**Pacific Brook Christian School, Muswellbrook (SSD-16858710)
Response to Submissions**

ATTACHMENT 1

Note: This map presents the maximum depths and levels for the proposed school with MC2 (Golf Course Flood Bund) development scenario

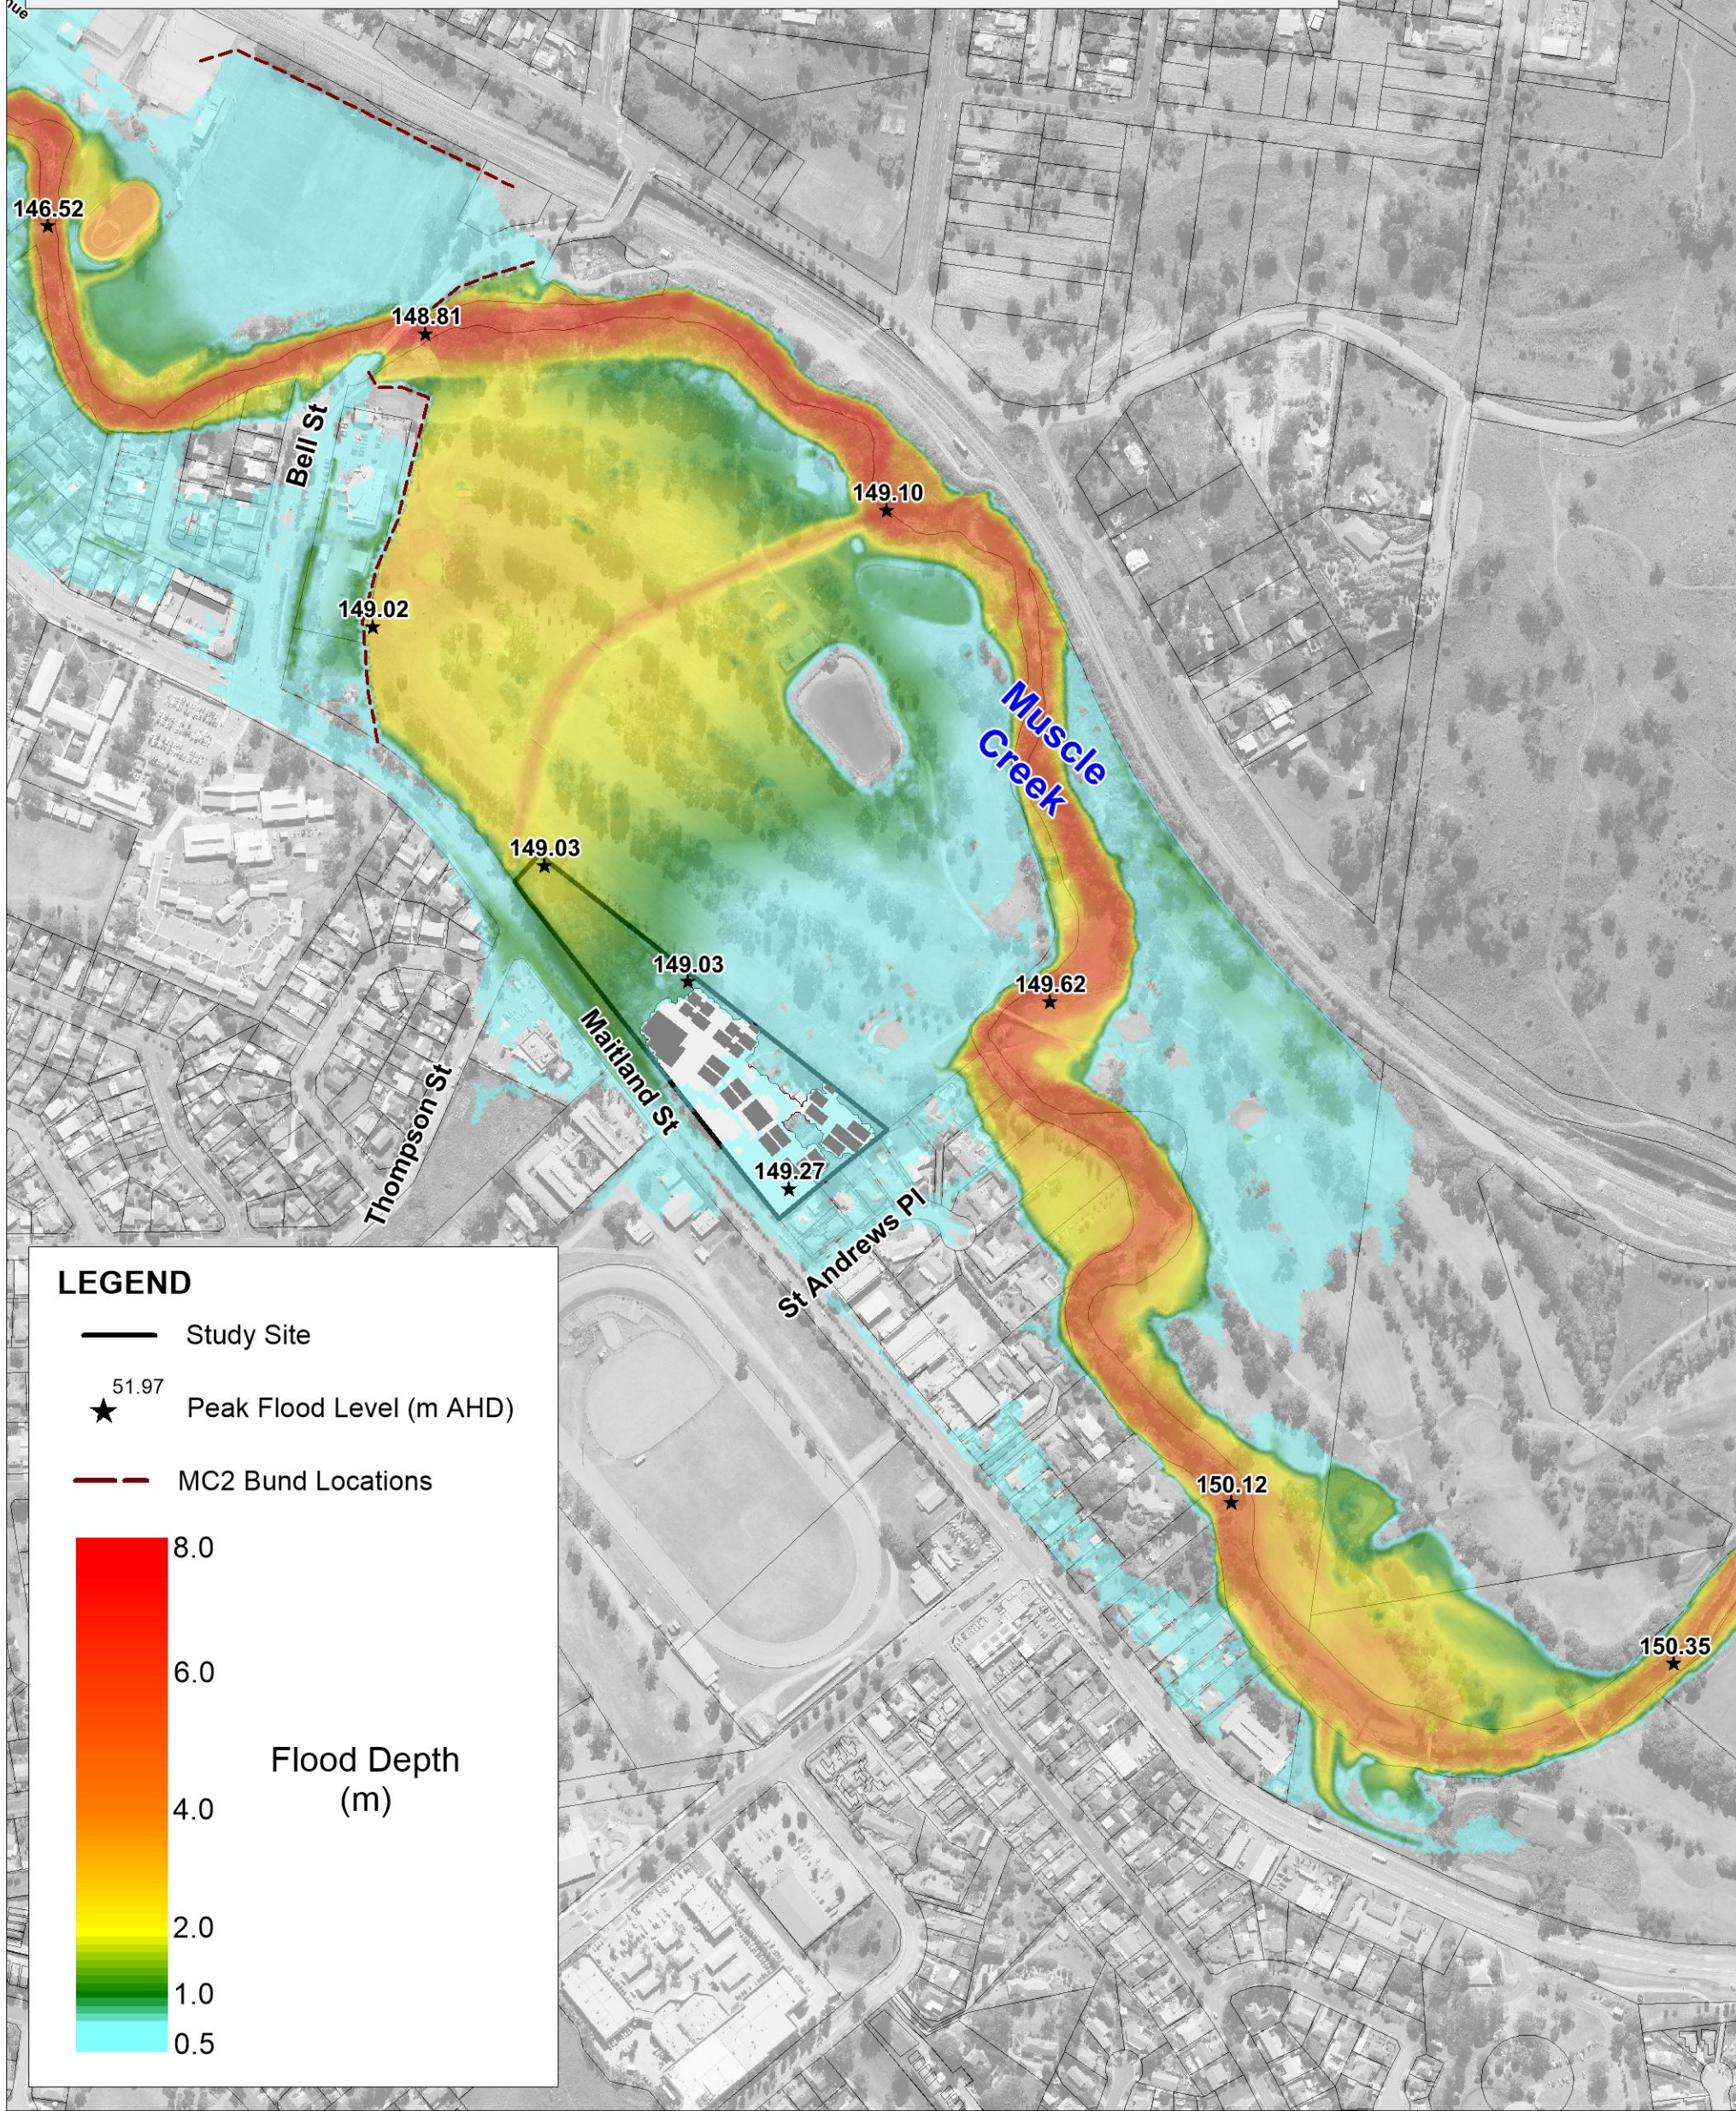
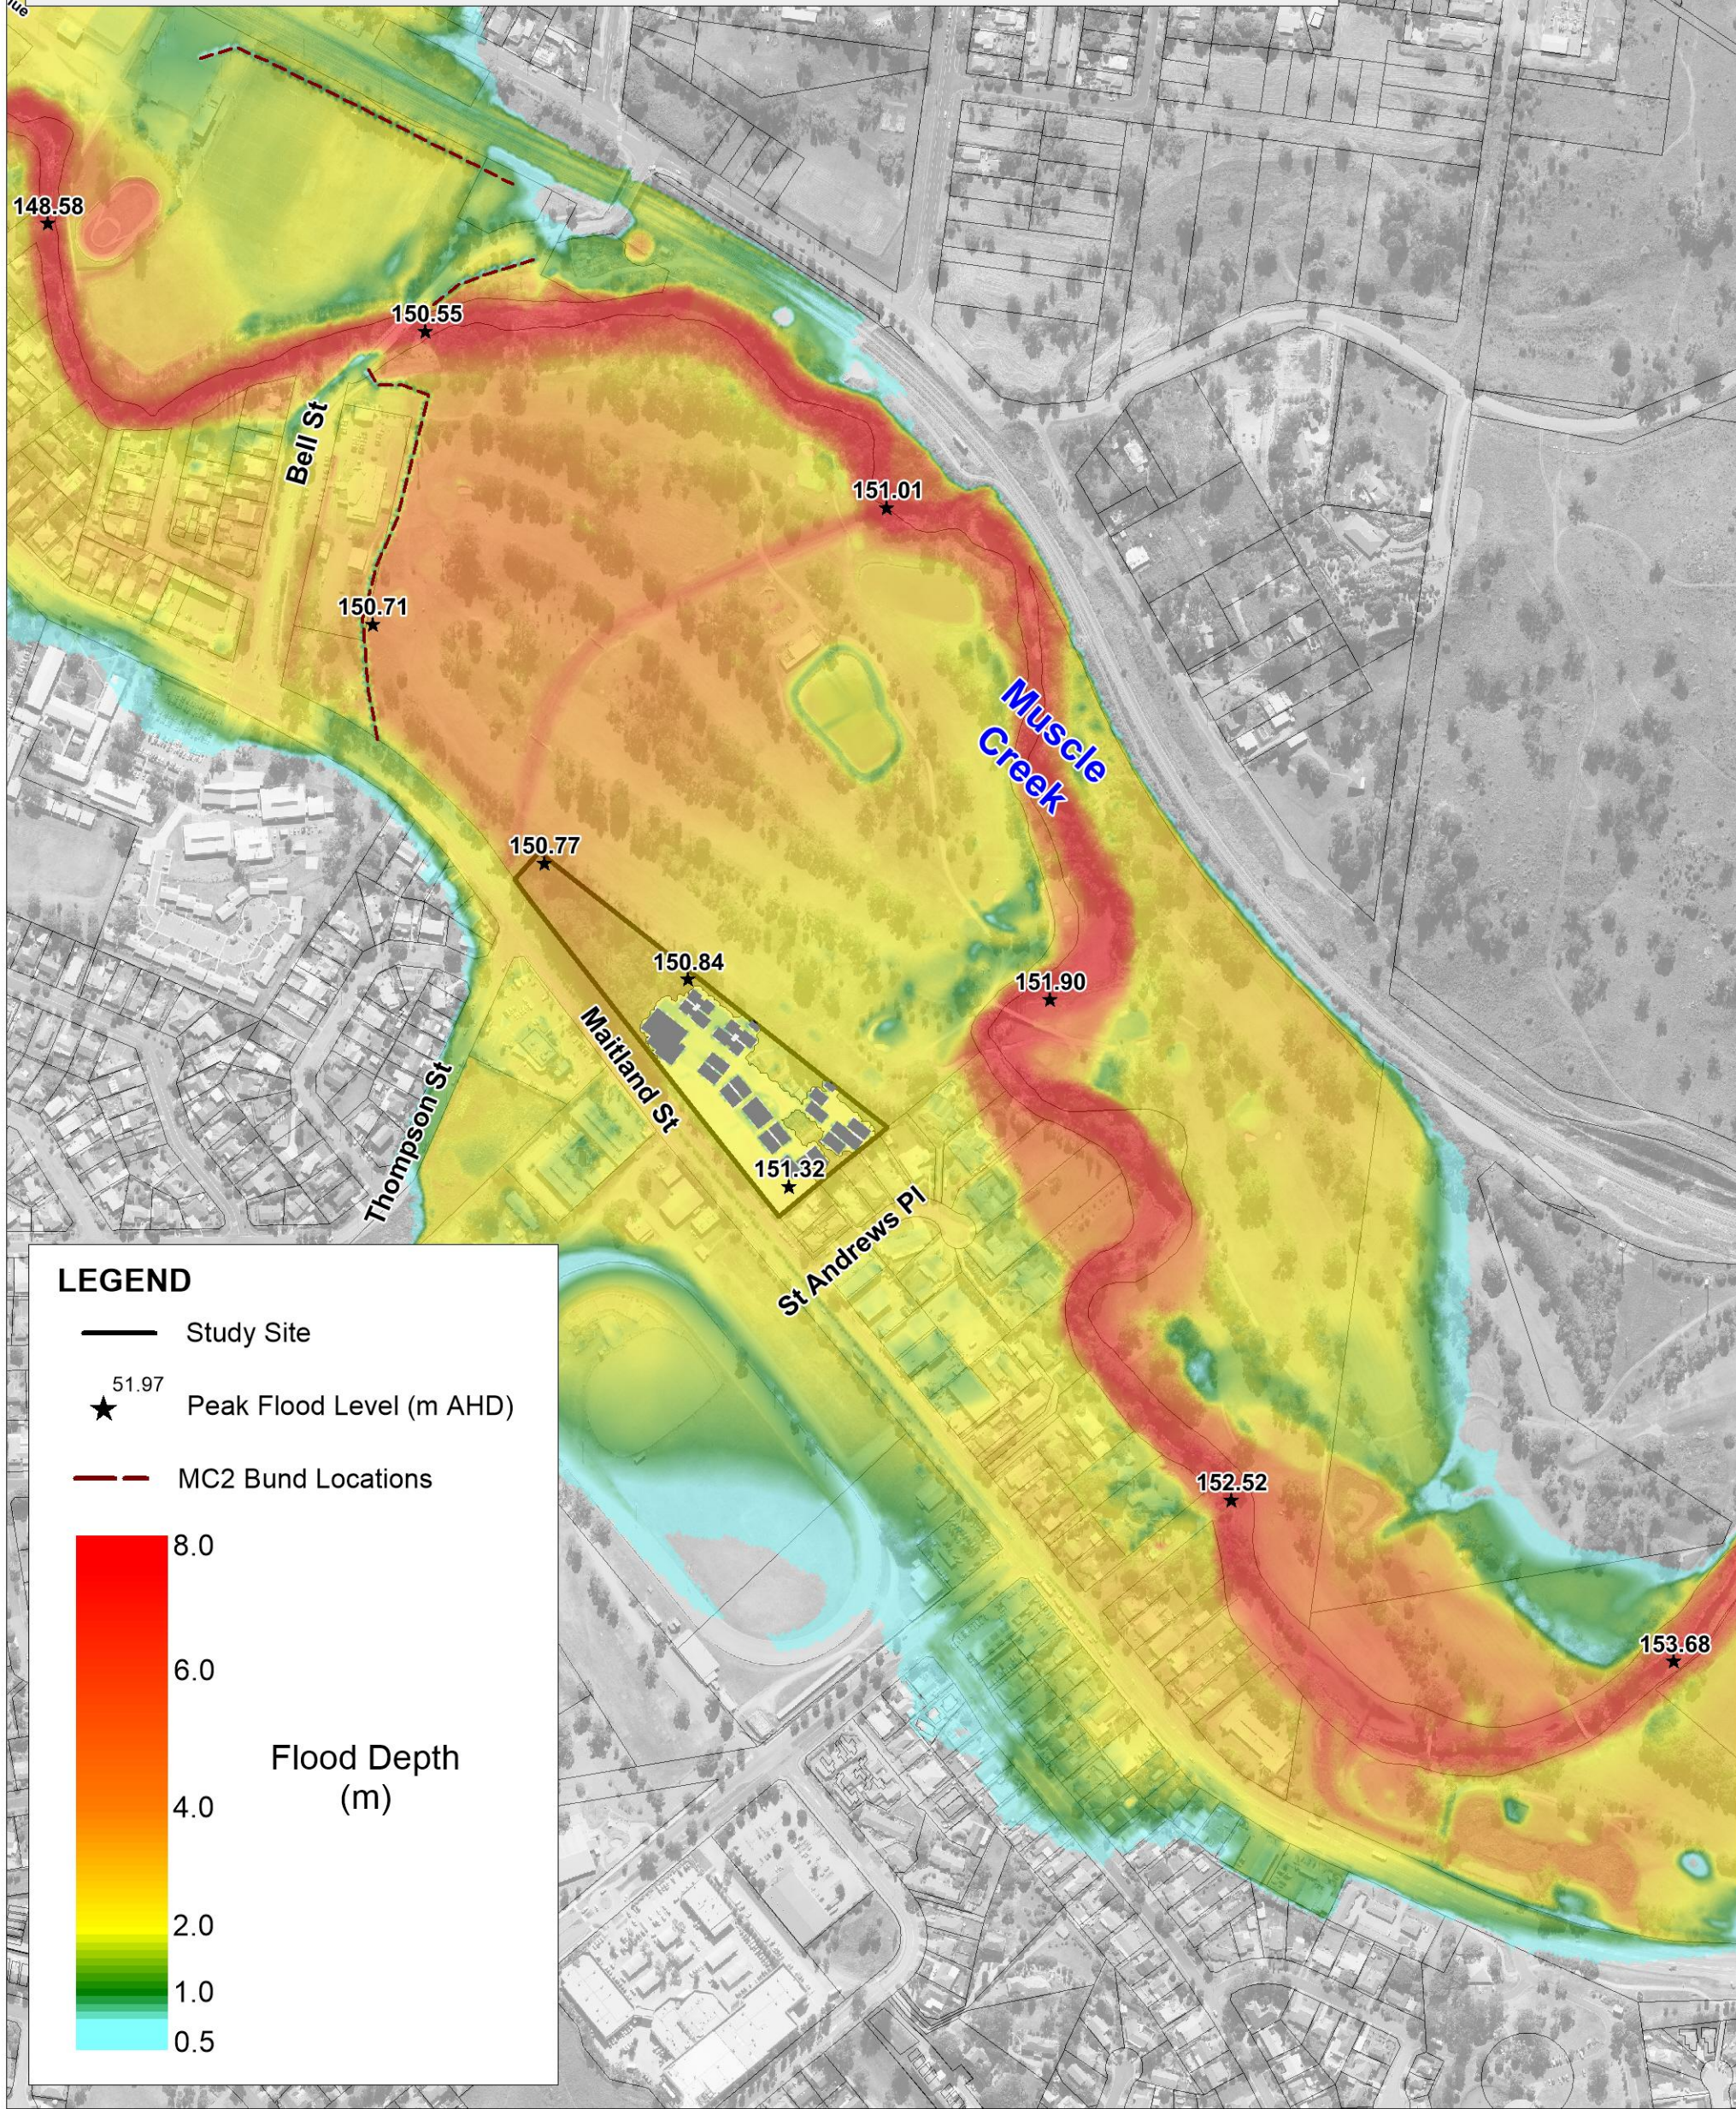
- Biodiversity and Conservation Division (BCD) have reviewed the proposal and raised substantial concerns with regard to flooding within the site. The Department shares the concerns of the BCD and requests that you amended your flooding report and respond to the comments raised by BCD.
- Additionally, the potential effects of climate change, sea level rise and an increase in rainfall intensity has not been adequately assessed. Please provide a more comprehensive flood assessment which addressed these impacts.
